CITY OF ALBUQUERQUE

**Re: Beehive Village at San Pedro-Building 2
6401 Corona NE
Requested for Permanent C. O. – Accepted
Engineers Stamp Date 6/23/11 (C18D016A)
Certification dated: 5-22-16**

DRAINAGE AND TRANSPORTATION INFORMATION SHEET

PROJECT TITLE: BeehiveVillage at San Pedro-phase 2
DRB #: _____ EPC #: _____

ENGINEER'S SEAL DAVID SOULE P.E. #14522	BEEHIVE HOMES	DRAWN BY WCVJ
	GRADING AND DRAINAGE PLAN	DATE 6-21-11
	Rio Grande Engineering 1806 CENTRAL AVENUE SUITE 201 ALBUQUERQUE, NM 87106 (505) 872-0999	2119-14522-6-01-10
		SHEET # 2
		JOB # 2119

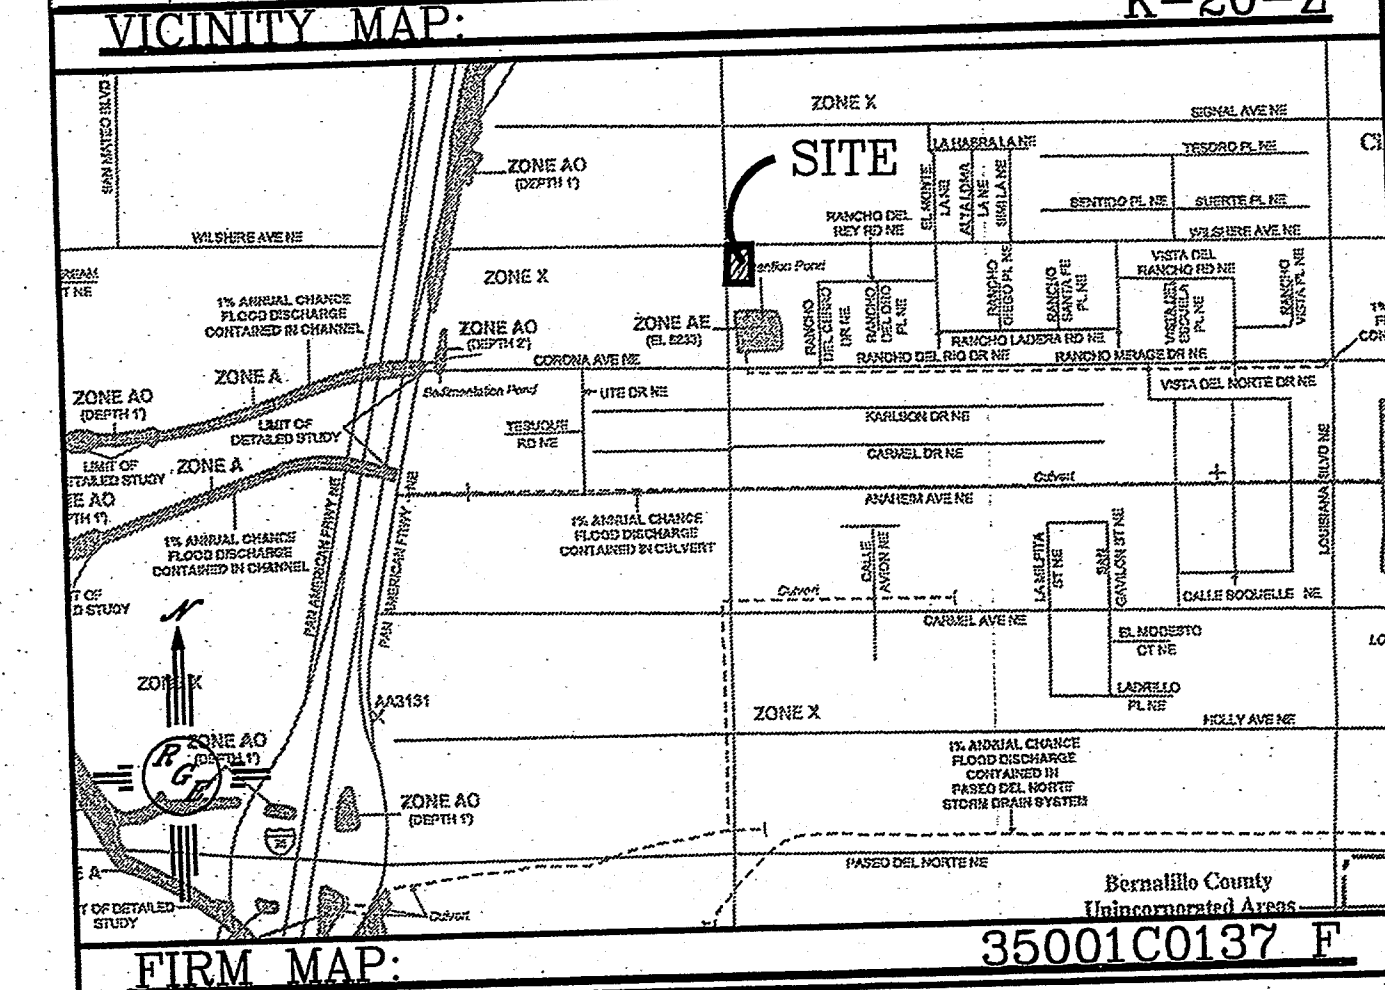
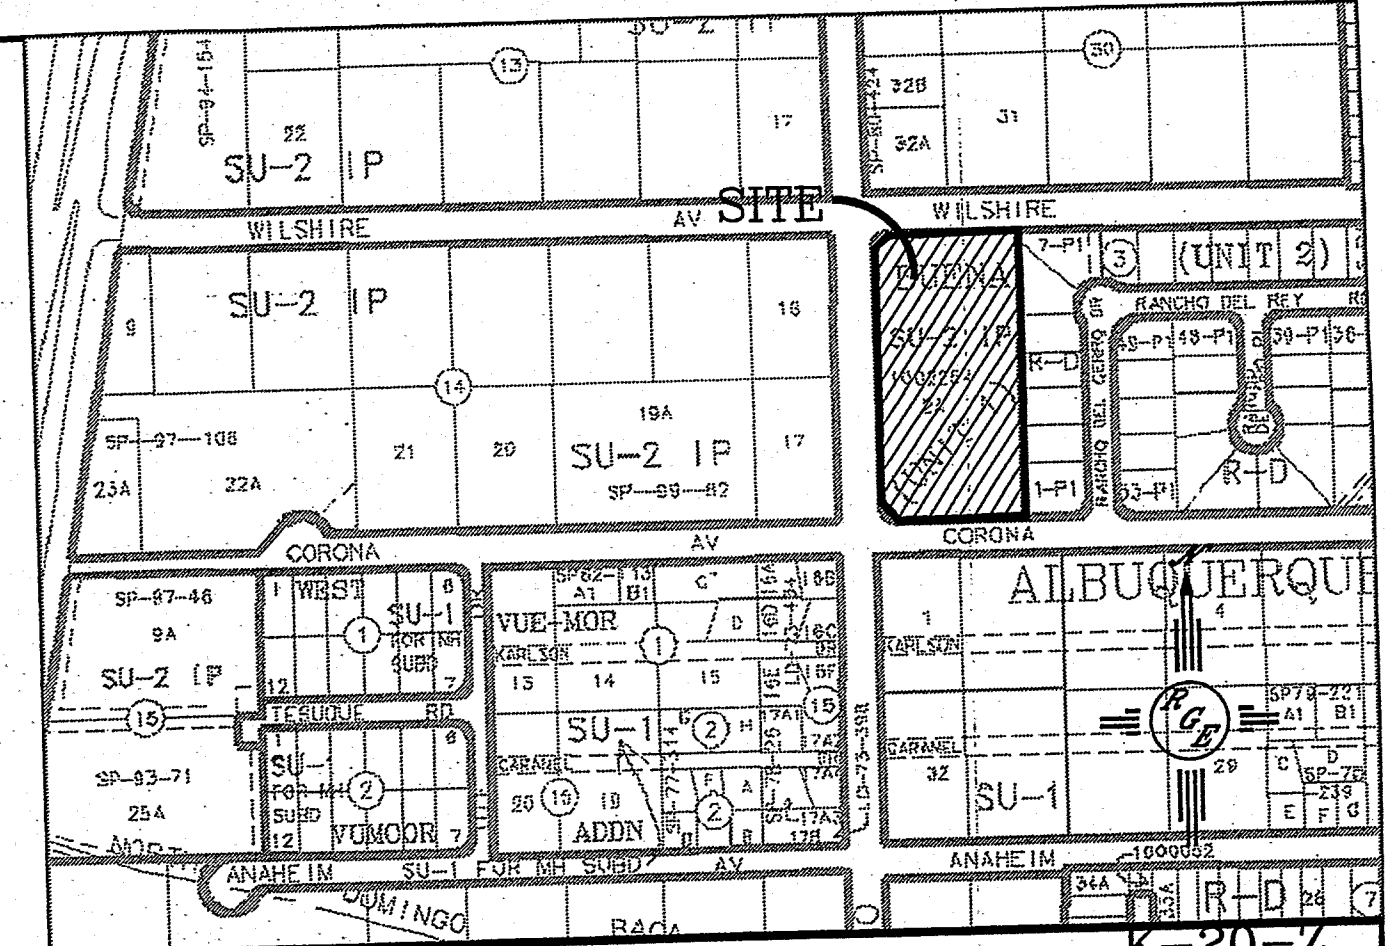
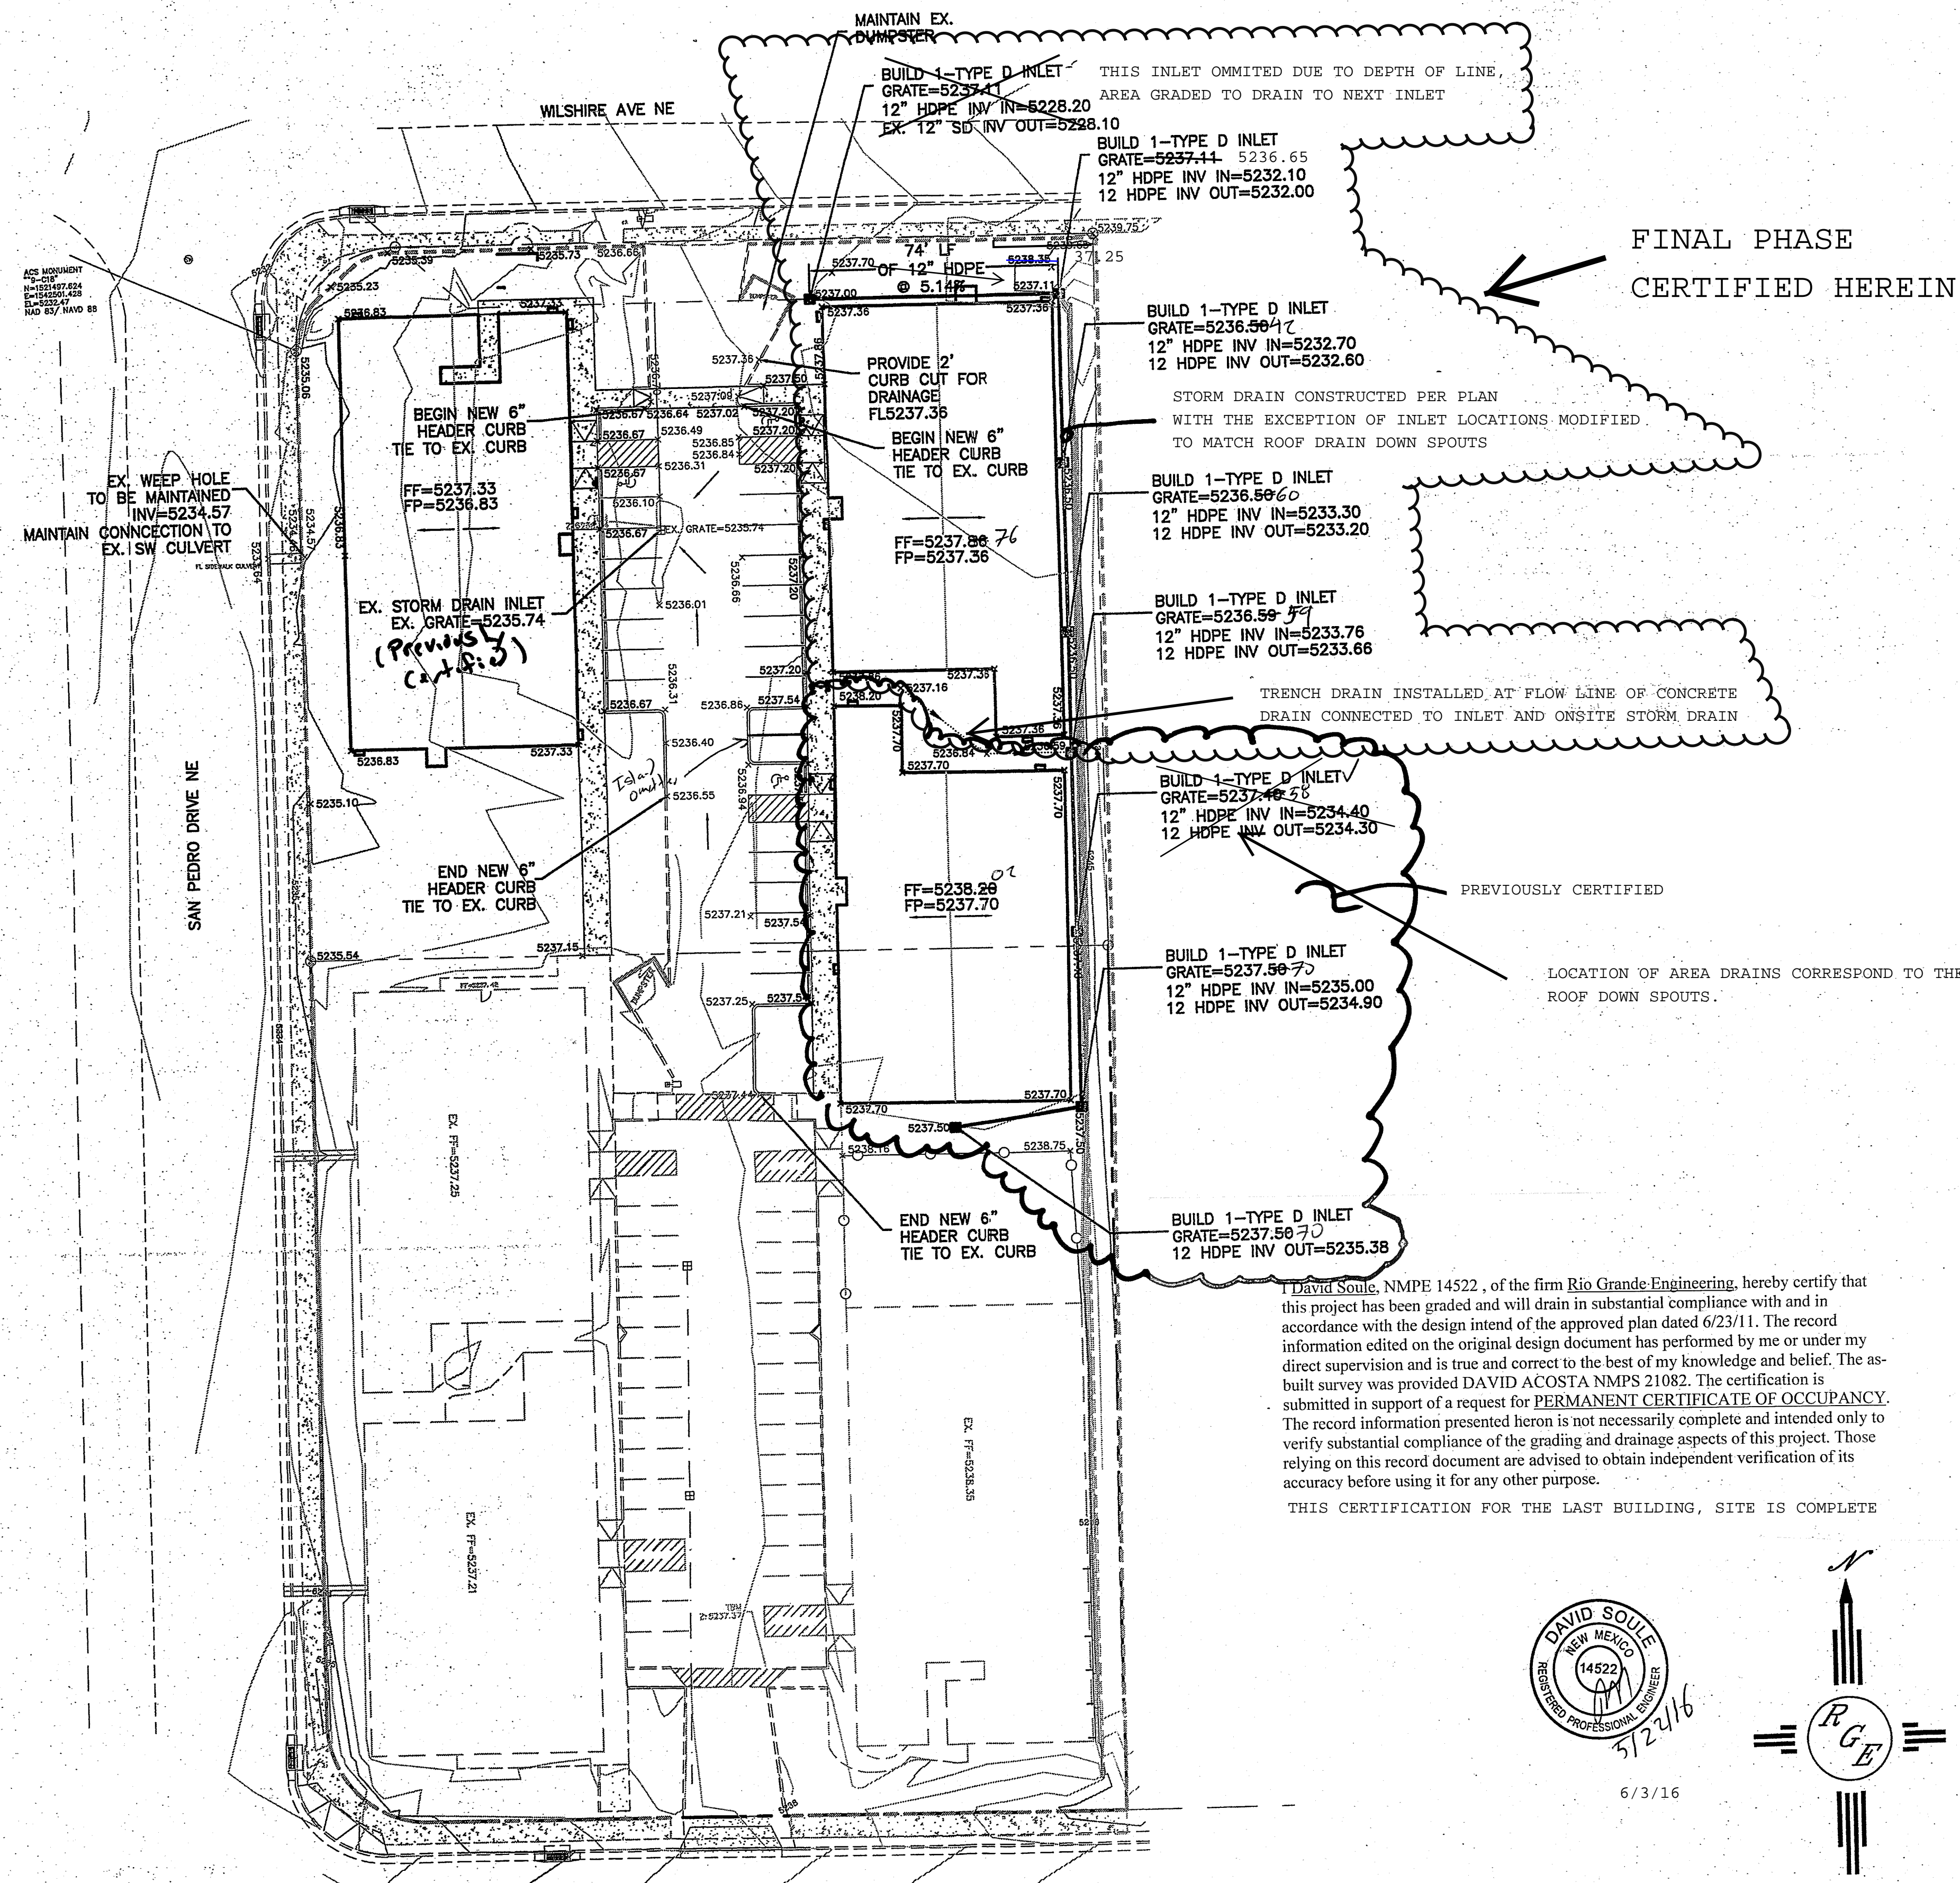
- In the future ensure that the as-built accurately reflects the final condition. One inlet was not crossed off of the drawing.

- In the future ensure that the roof drains do not flow over a pedestrian sidewalk.
